CITY OF ALBUQUERQUE

**RE: Santa Barbara Subdivision Replat of Lot 2 Block 16
Grading & Drainage Plan and Drainage Calculation Report
Engineer's Stamp Date: 06/13/22
Hydrology File: D19D001F**

RE: Hydrology File: D19D001F, Santa Barbara Subdivision Replat – Response to Comments

CITY OF ALBUQUERQUE	
	DEPARTMENT OF MUNICIPAL DEVELOPMENT	
	ENGINEERING DIVISION	
	SANTA BARBARA IMPROVEMENTS	
GRADING AND DRAINAGE PLAN		ZONE MAP NO.
DESIGN REVIEW COMMITTEE		CITY ENGINEER APPROVAL
CITY PROJECT NO.		NA
SHEET NO.		1 of 2

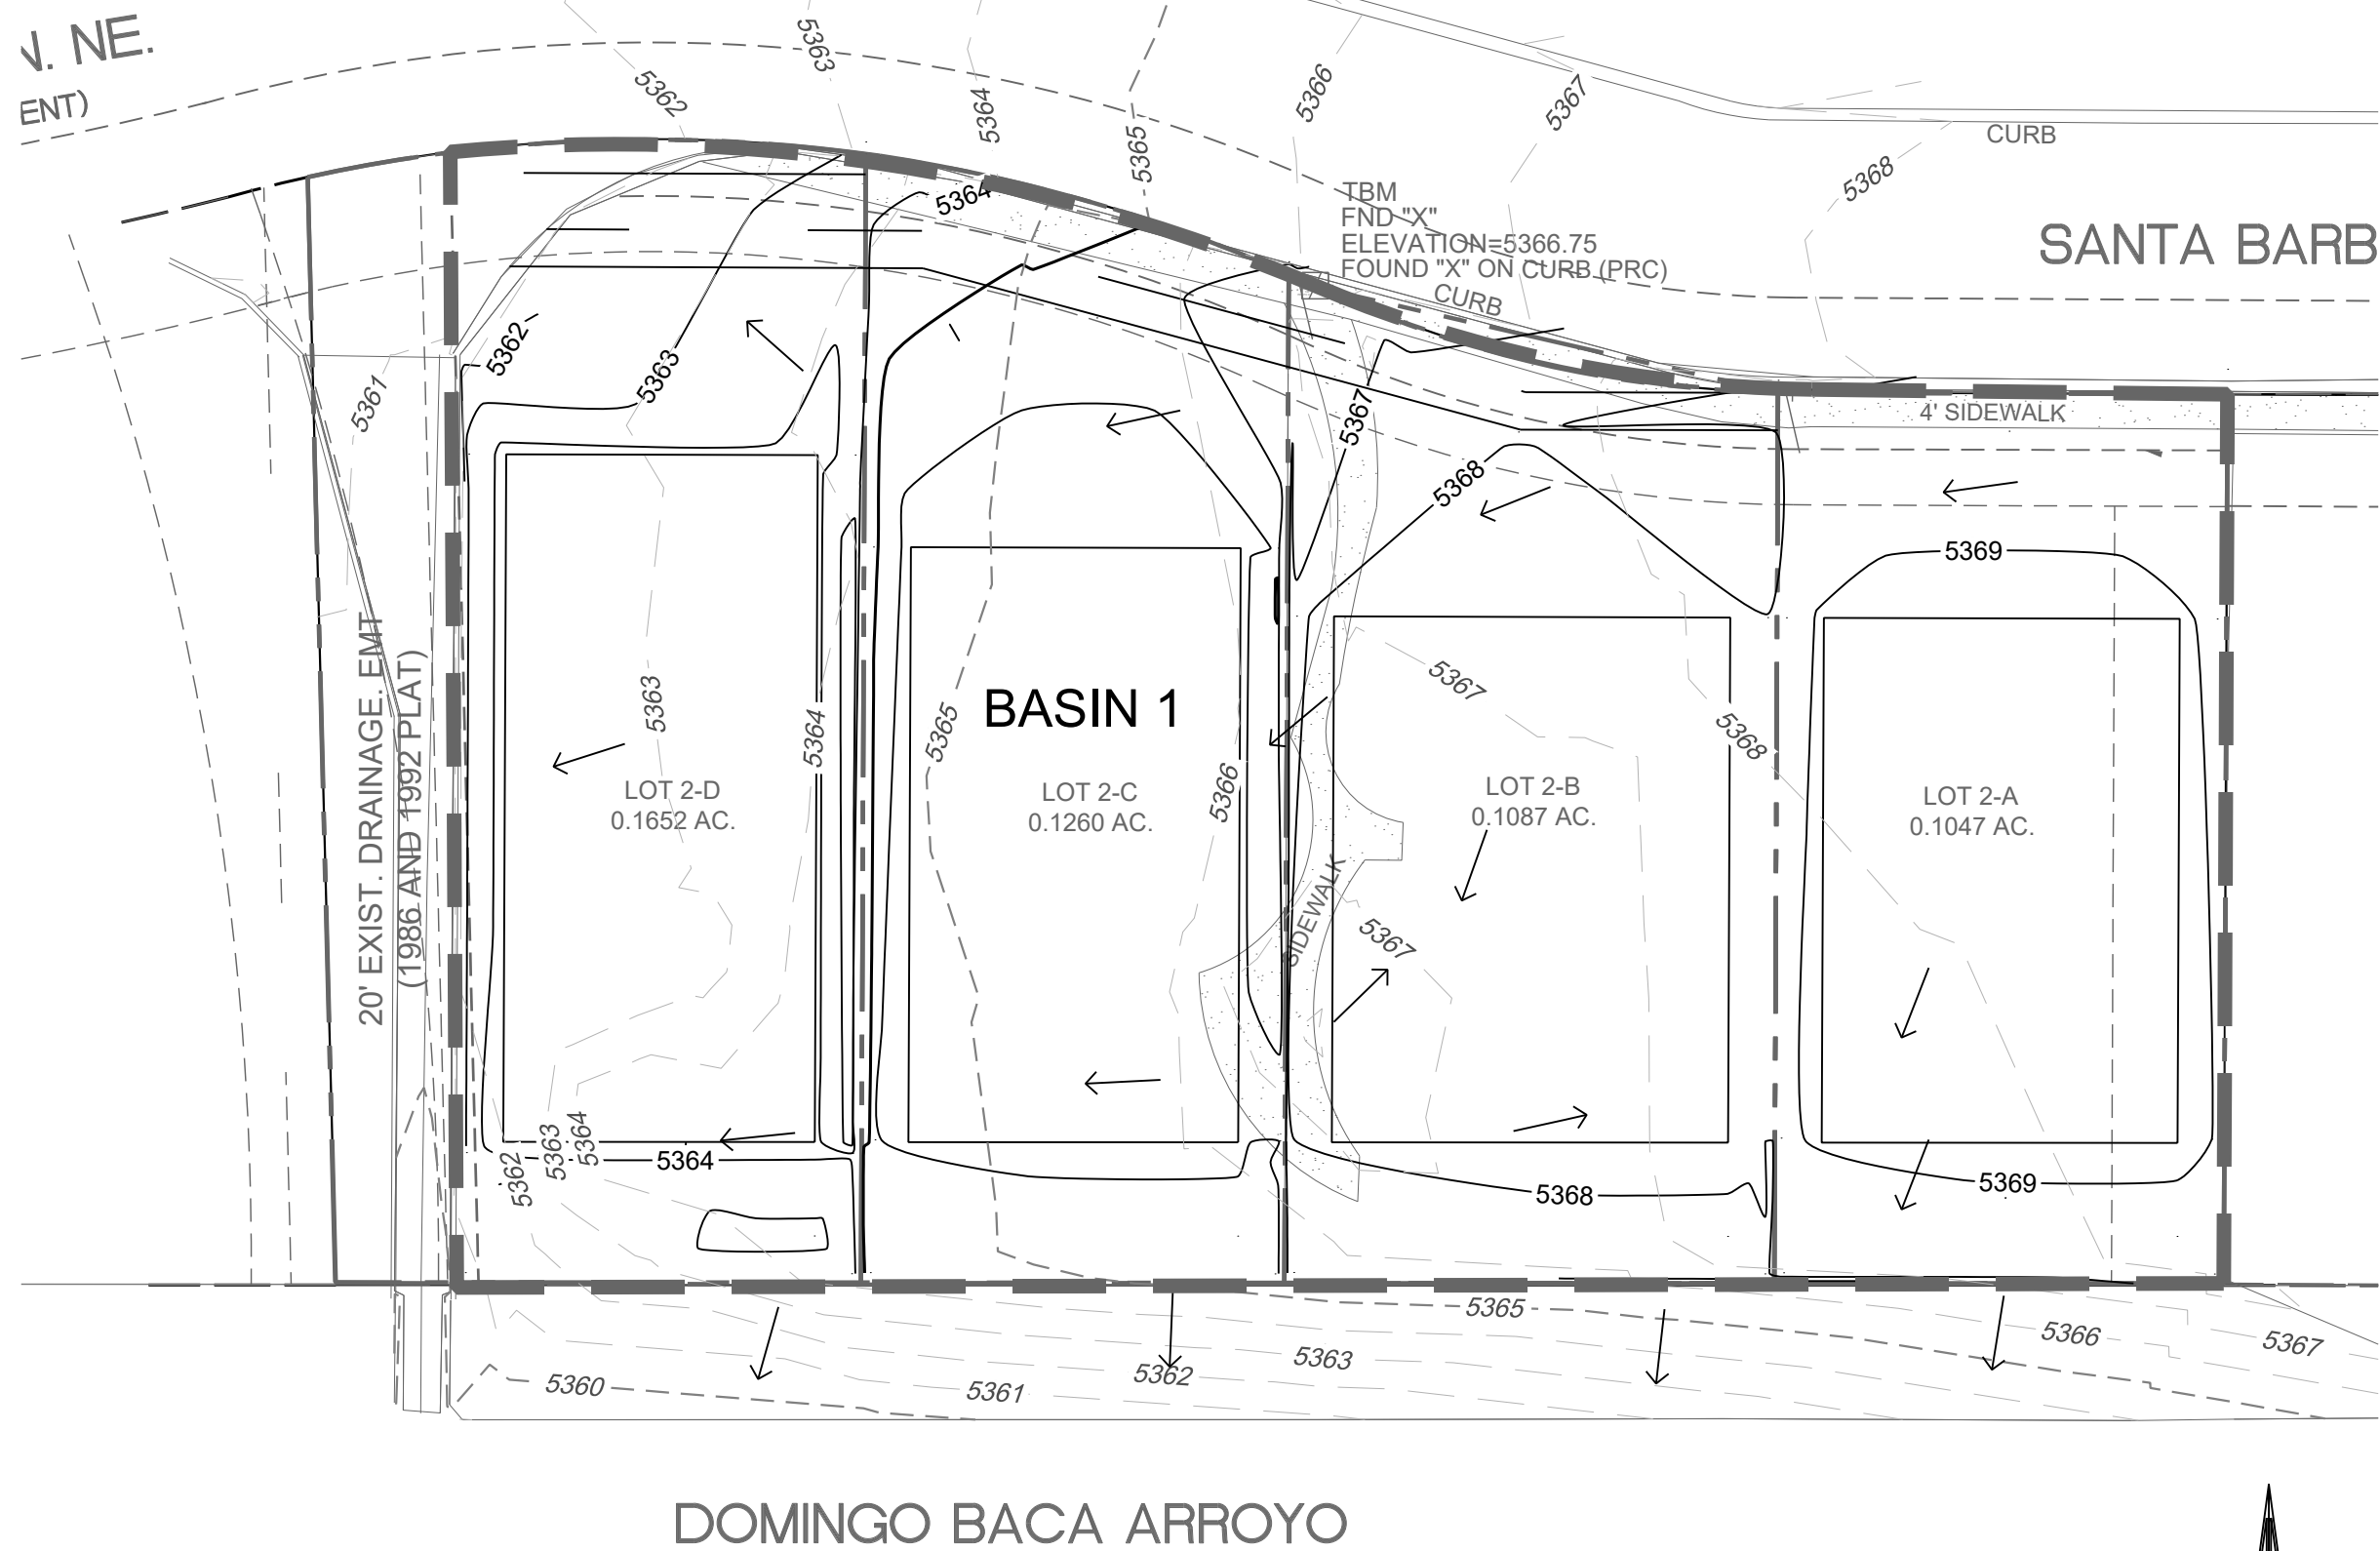
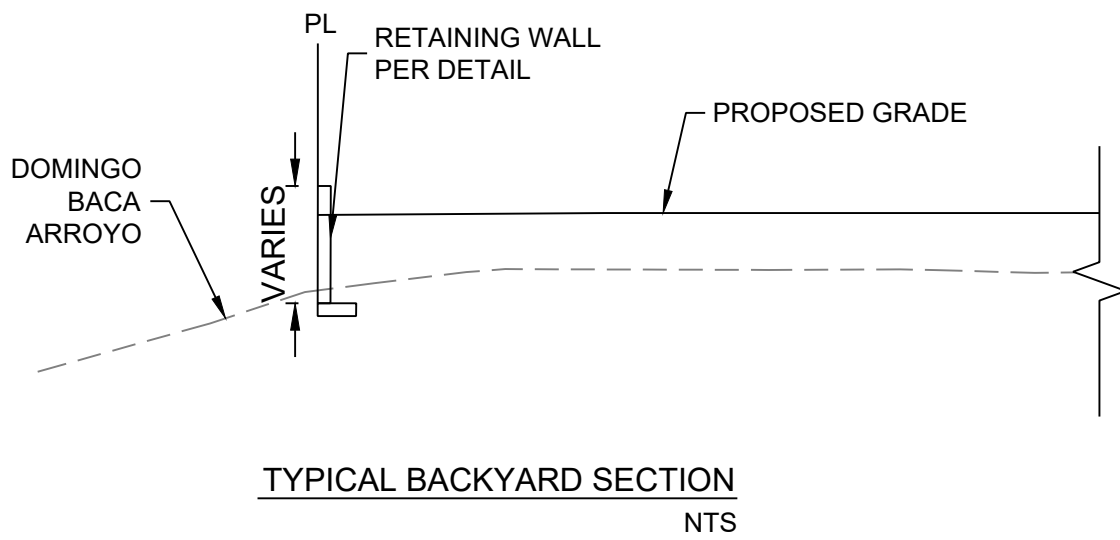
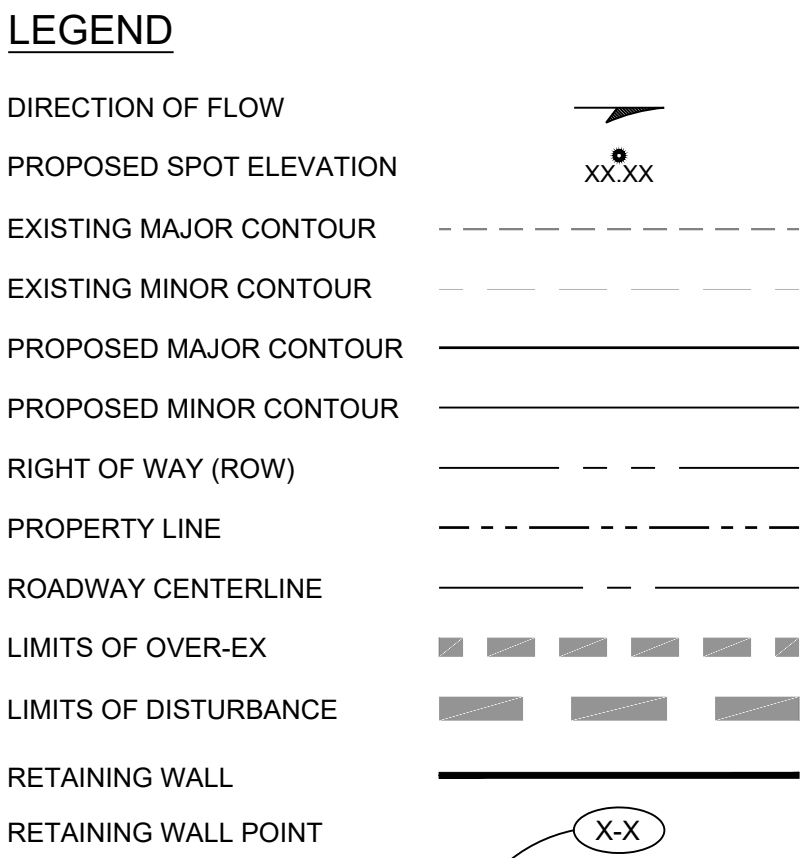
Comment 3: Please use the procedure for 40 acre and smaller basins as outlined in Development Process Manual (DPM) Article 6-2(a). Please provide both the existing conditions and proposed conditions for the 100 year-6 hour storm event.

Comment 4: Please also include the existing and proposed calculations for the existing concrete channel. Please use the entire watershed that goes into this channel. This being said, an aerial can be used to show the extent of the watershed. I want to ensure that the concrete channel will be able to handle the change from what is there now and when the lot is converted to townhomes.

Comment 5: The existing 20' Private Drainage Easement which has the existing concrete channel needs to be converted to Tract A which is owned and maintained by the HOA. This easement should not be part of Lot 2-D.

Comment 6: Typically, the drive pad cannot be built on a radius. Please consult Transportation Section.

Response: AHYMO Calculations are provided with the resubmittal.

Response: Channel Calculations are provided with the resubmittal.

Response: A separate Tract is now being proposed for the Channel.

Response: Discussions/coordination has alleviated any Transportation concerns.

BACKGROUND

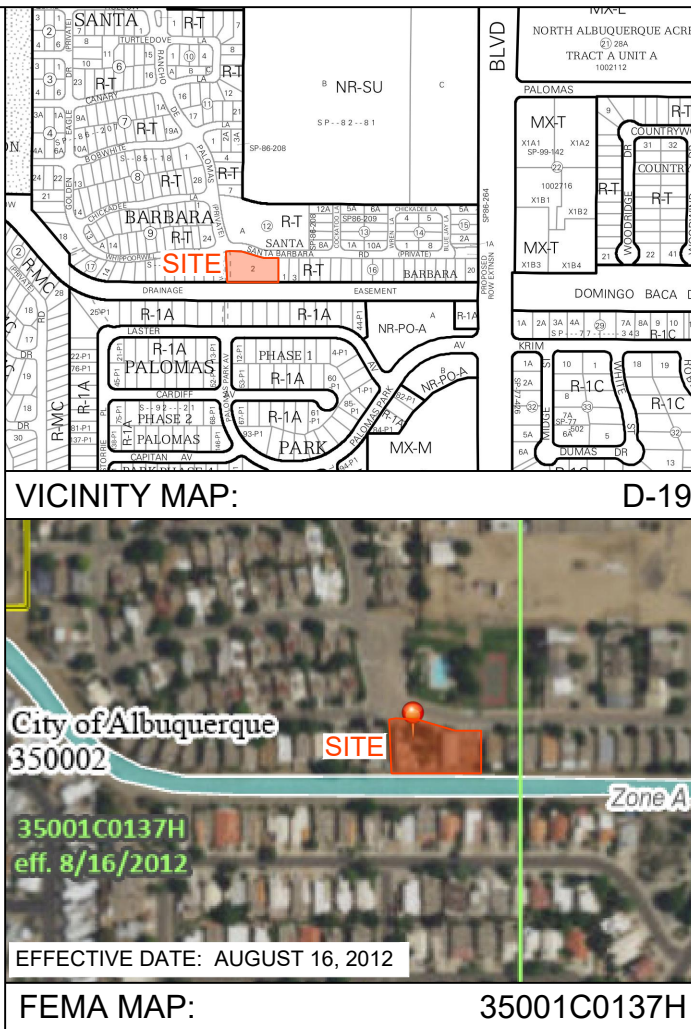
Comment 1: Under the Background. Please fix the Block information. This is Block 16 and not Block 17.

Comment 2: Under the Methodology. Please refer to Article 6-2(a) of the Development Process Manual (DPM) and not Chapter 22 (this was the old DPM).

Response: Revised Accordingly.

Response: Revised Accordingly.
